Summary of Comments on P:\100\100.051\prelim plan\early grading\100.051early grading cover sheet C0.1 (1)

Summary of Comments on Microsoft Word - 100.051-swmp

CREEKSIDE SOUTH AT LORSON RANCH

PUD SP-20-001

DATE:
JANUARY 15, 2020
PROJECT NO.
100.051
SHEET NUMBER
C9.5
TOTAL SHEETS: 15

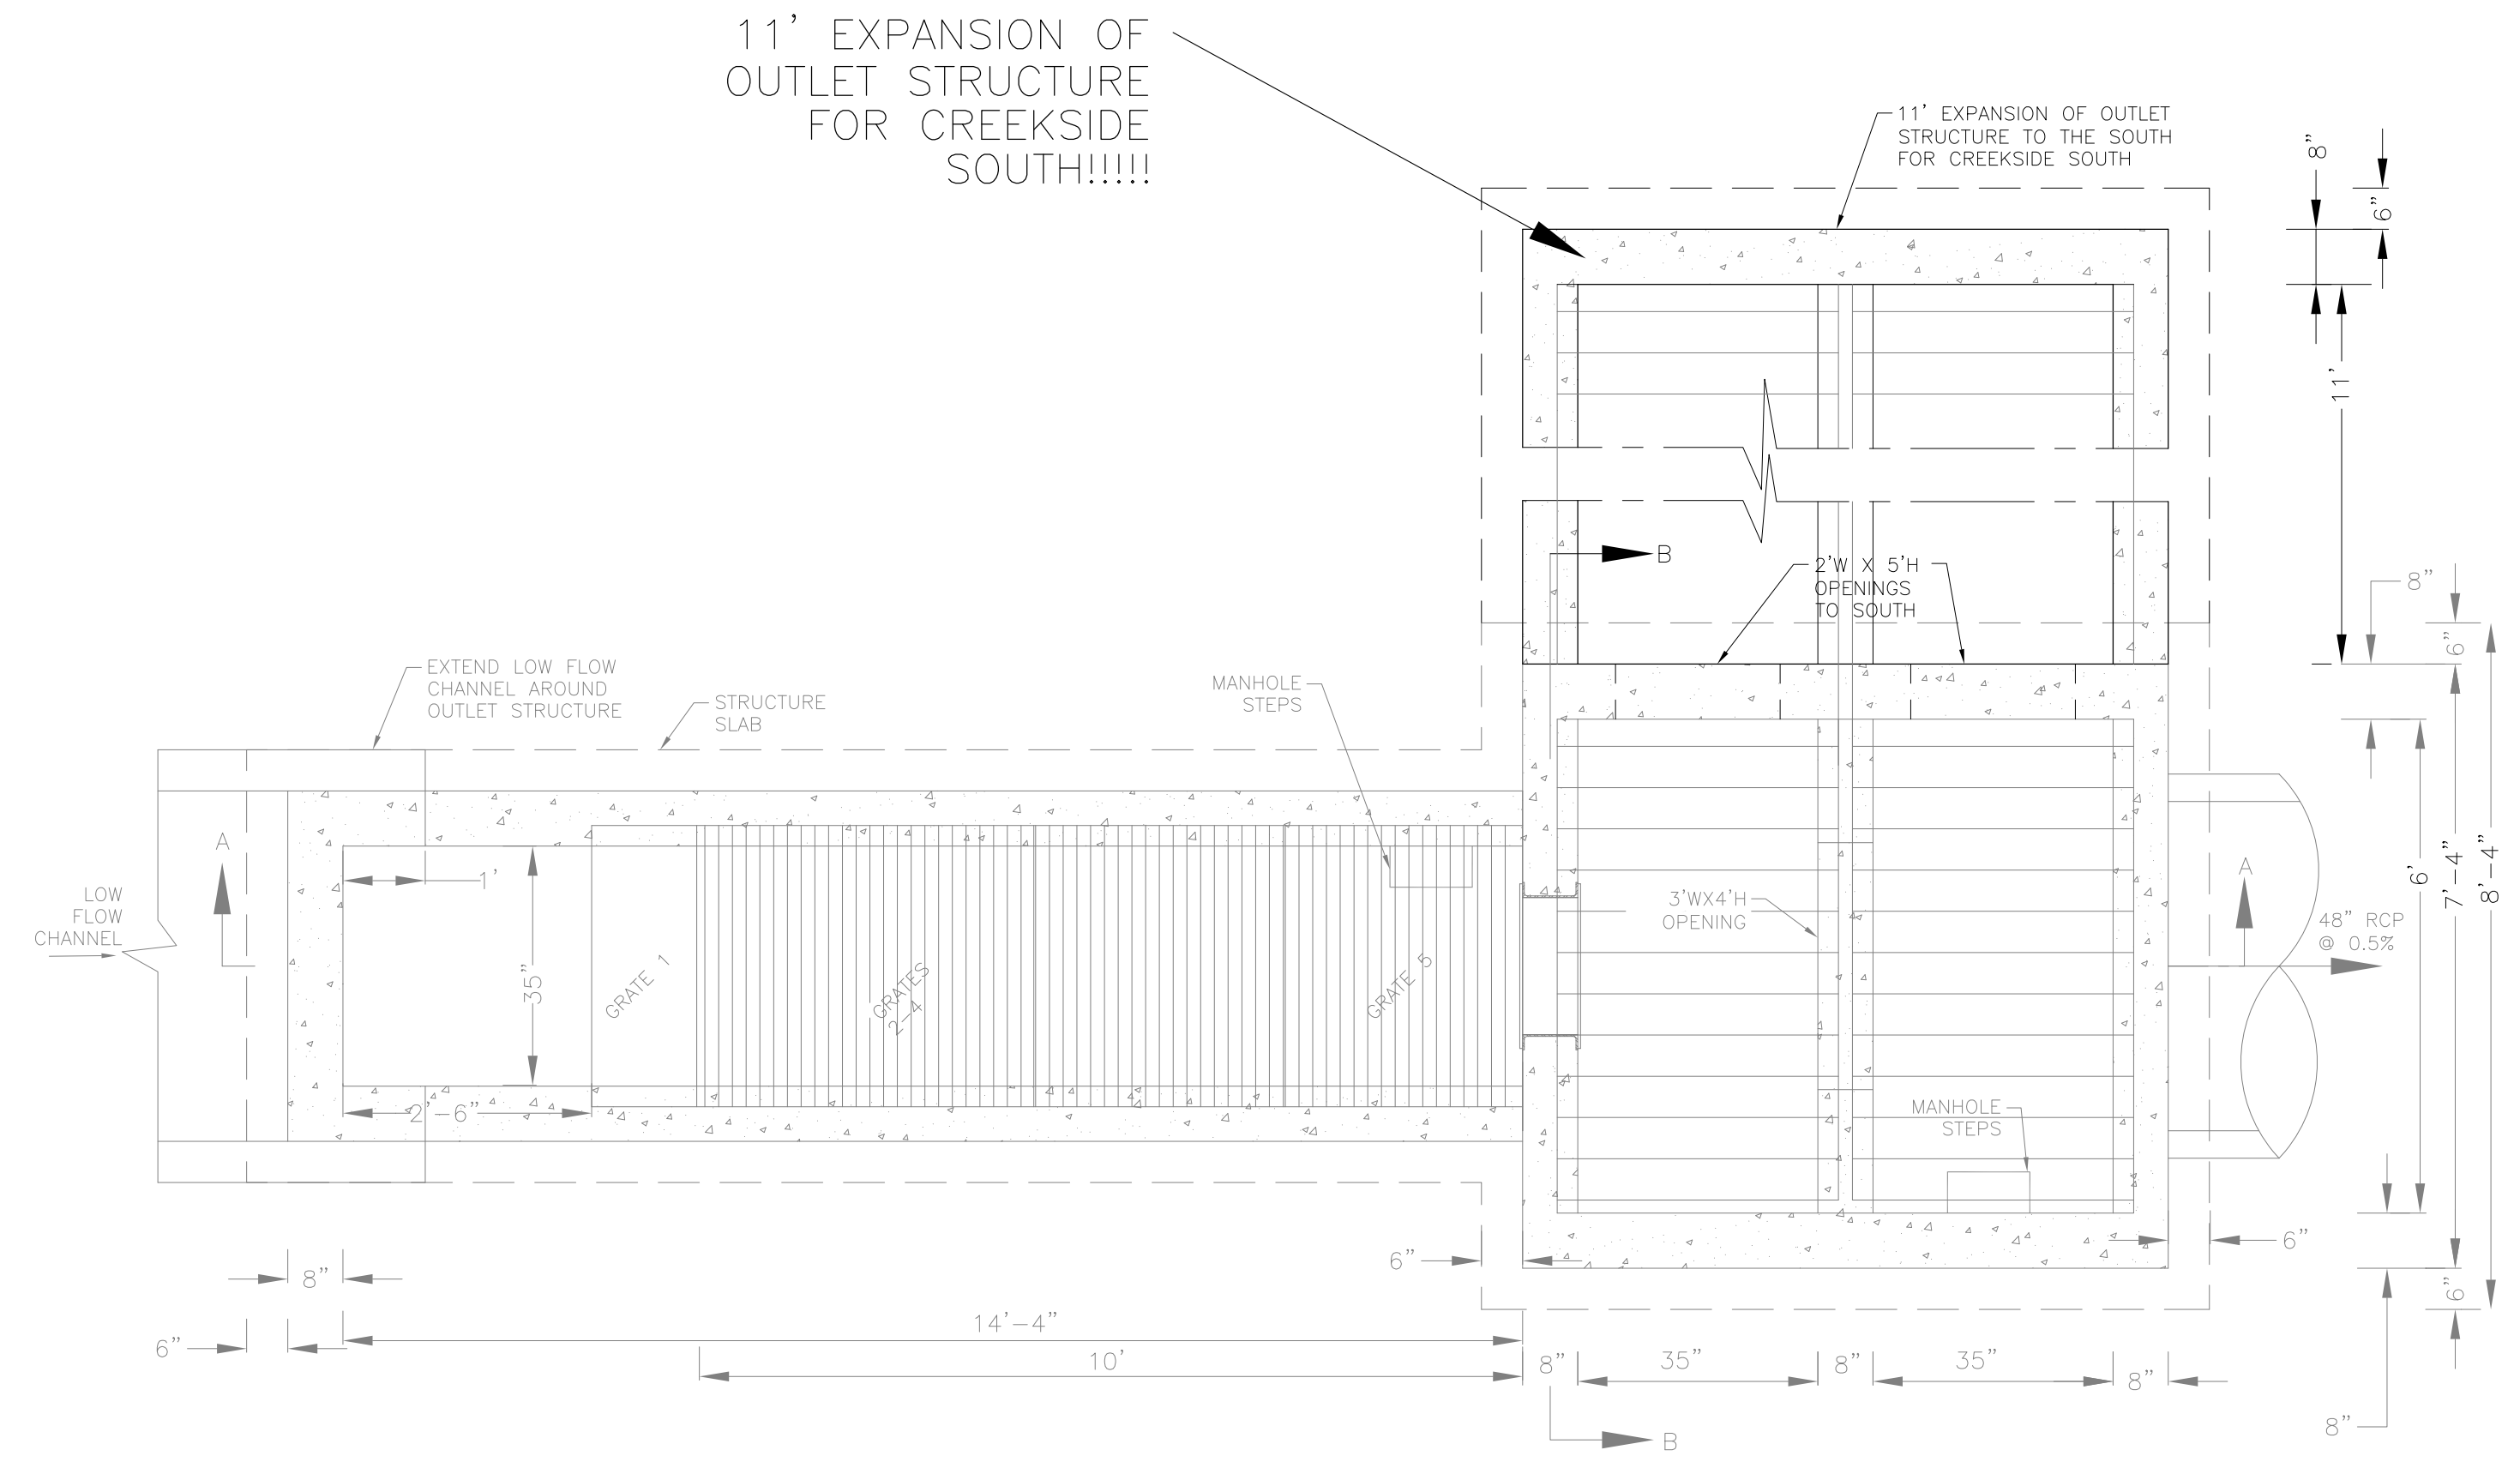
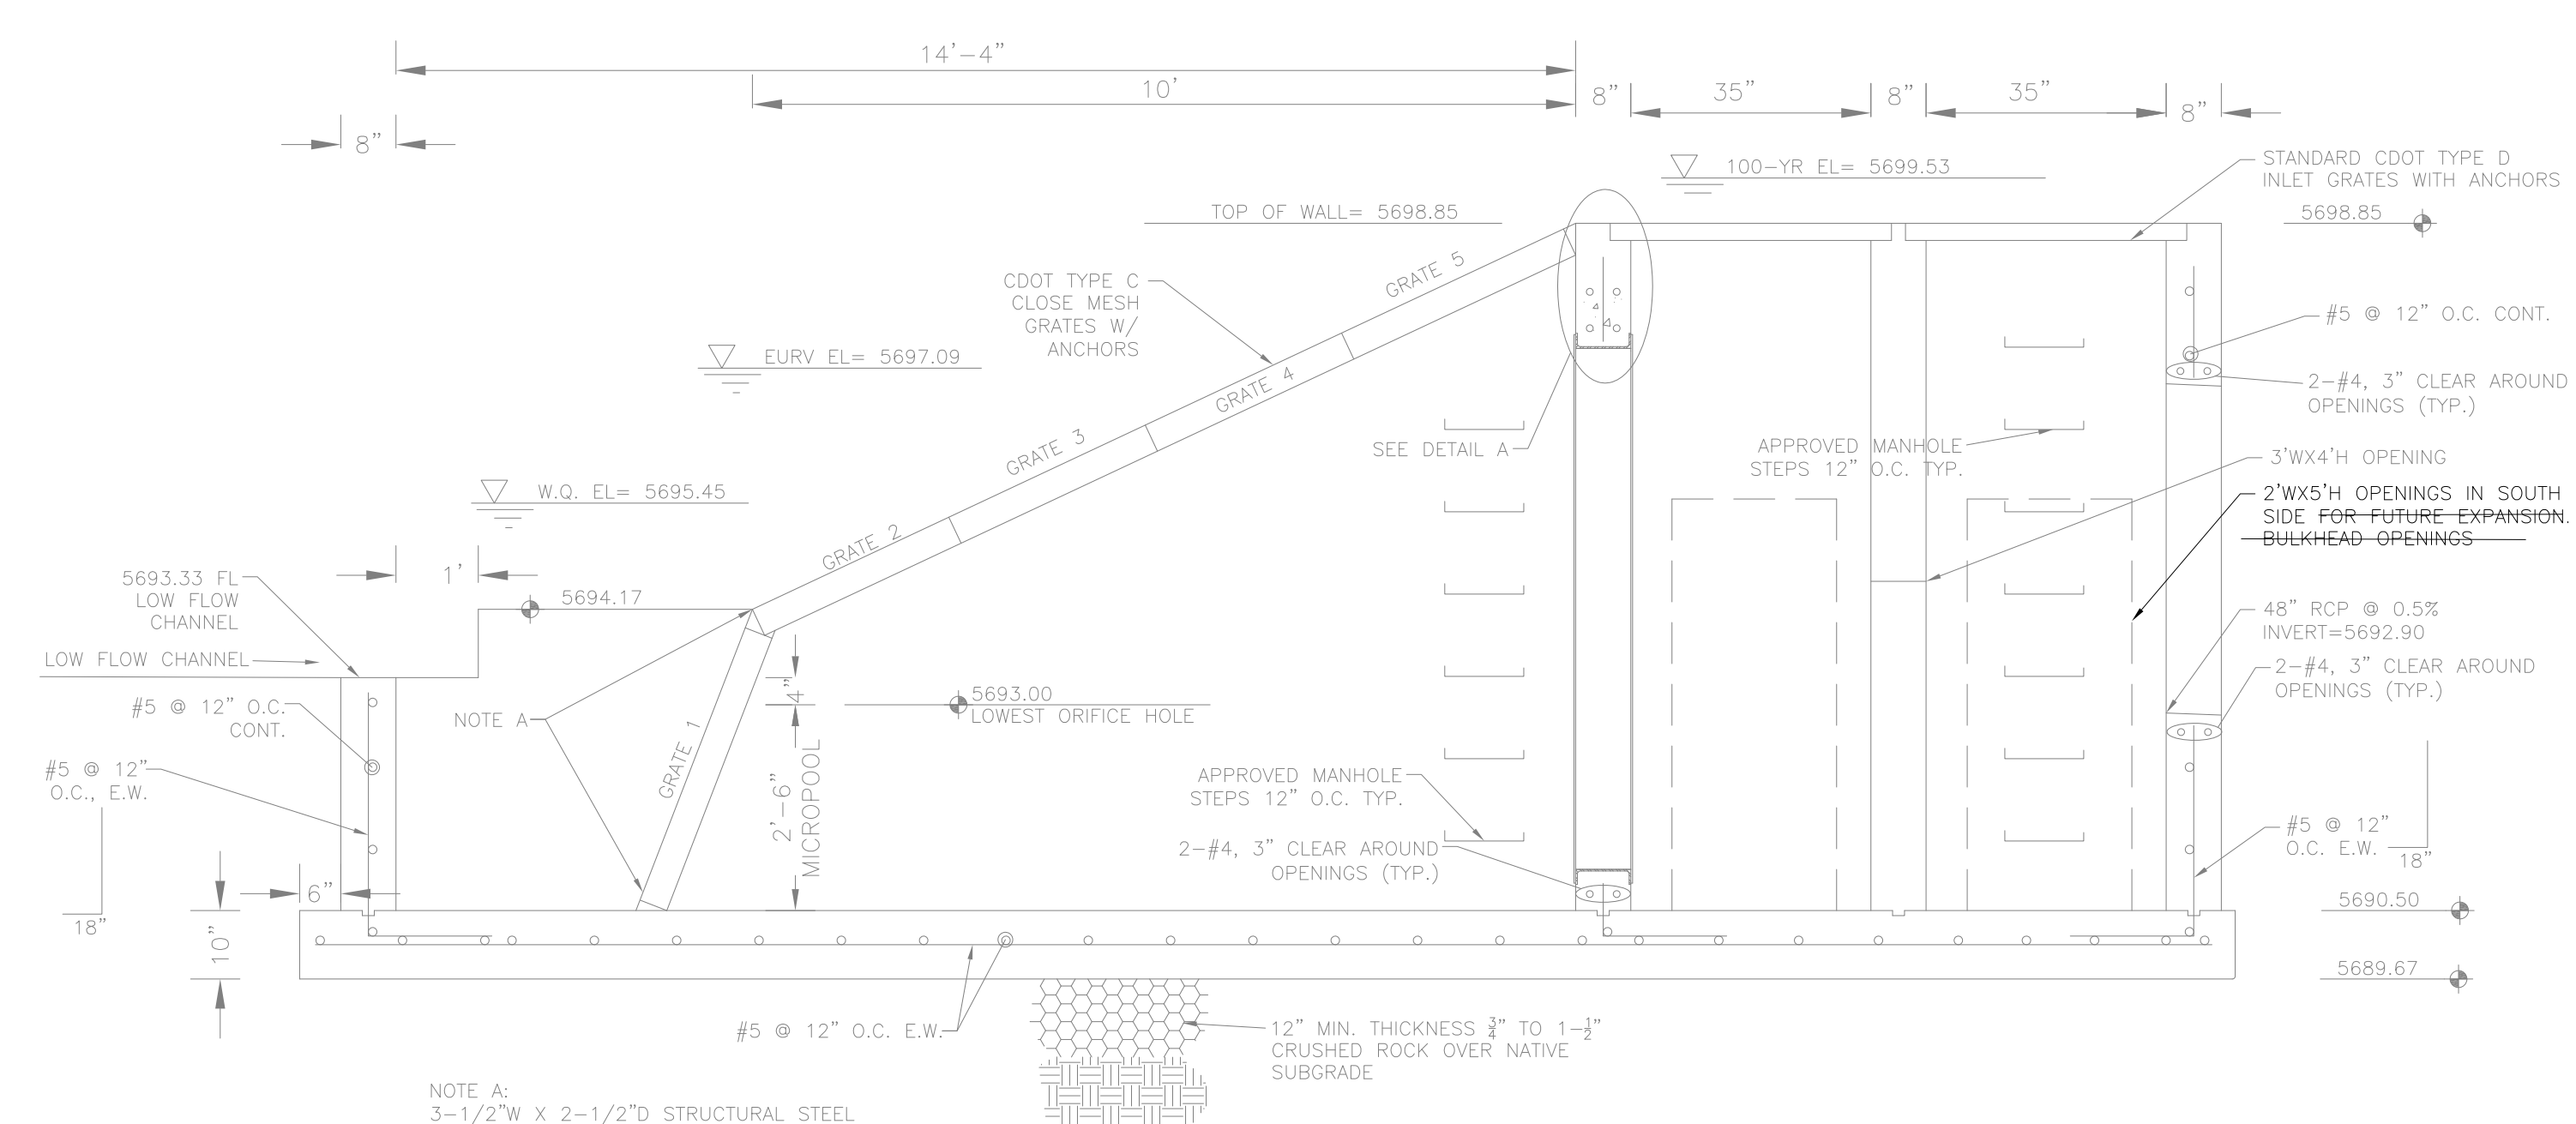
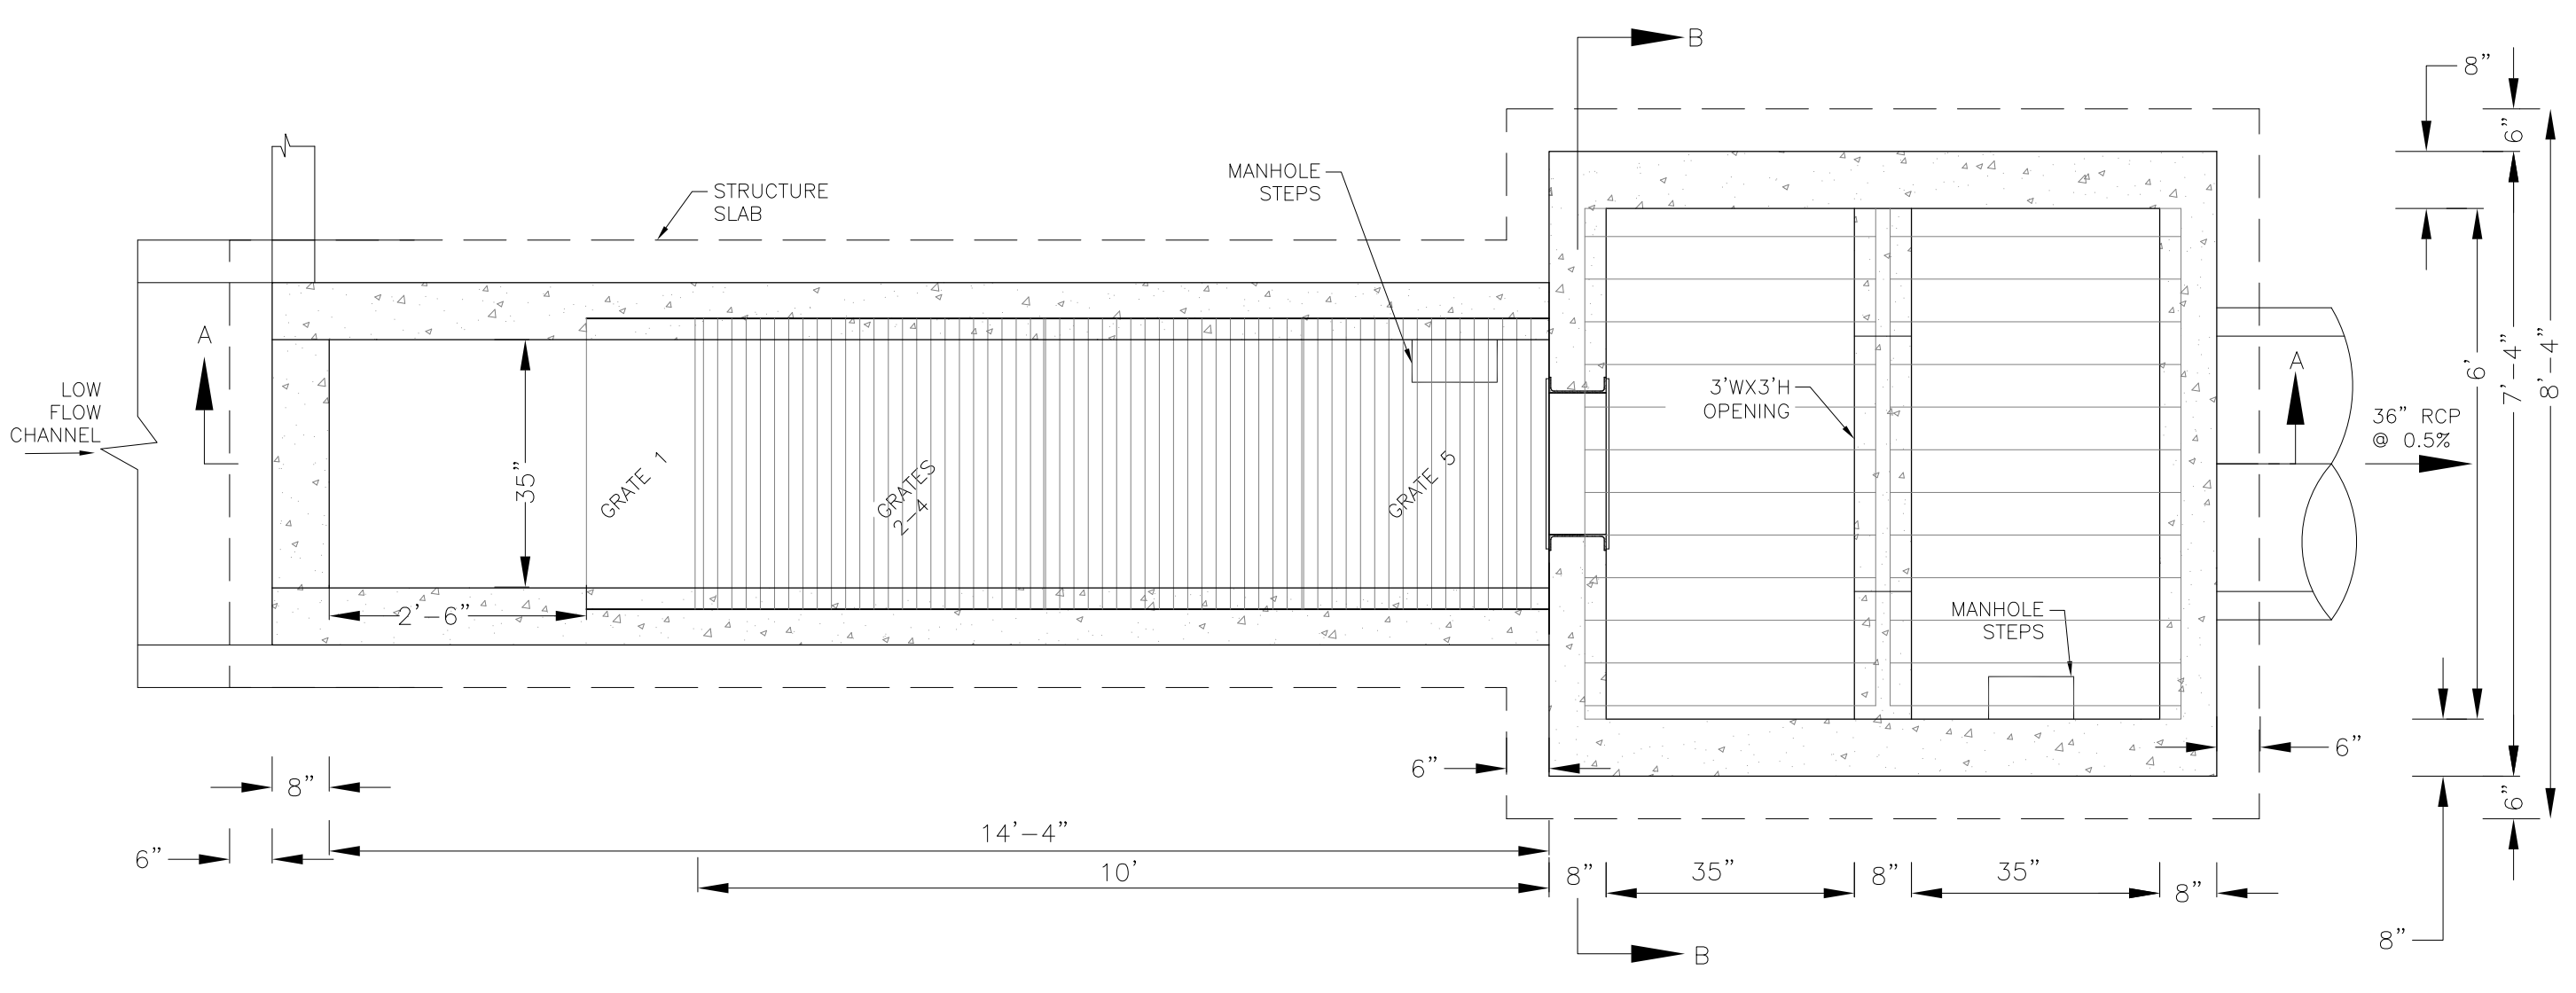
Label elevations. Are you going to specify method of construction (drilling/grinding vs torch?) or required finish (not rough)?

ELEVATIONS LABELED. DRILL/CUT HOLES. SMOOTH EDGES.
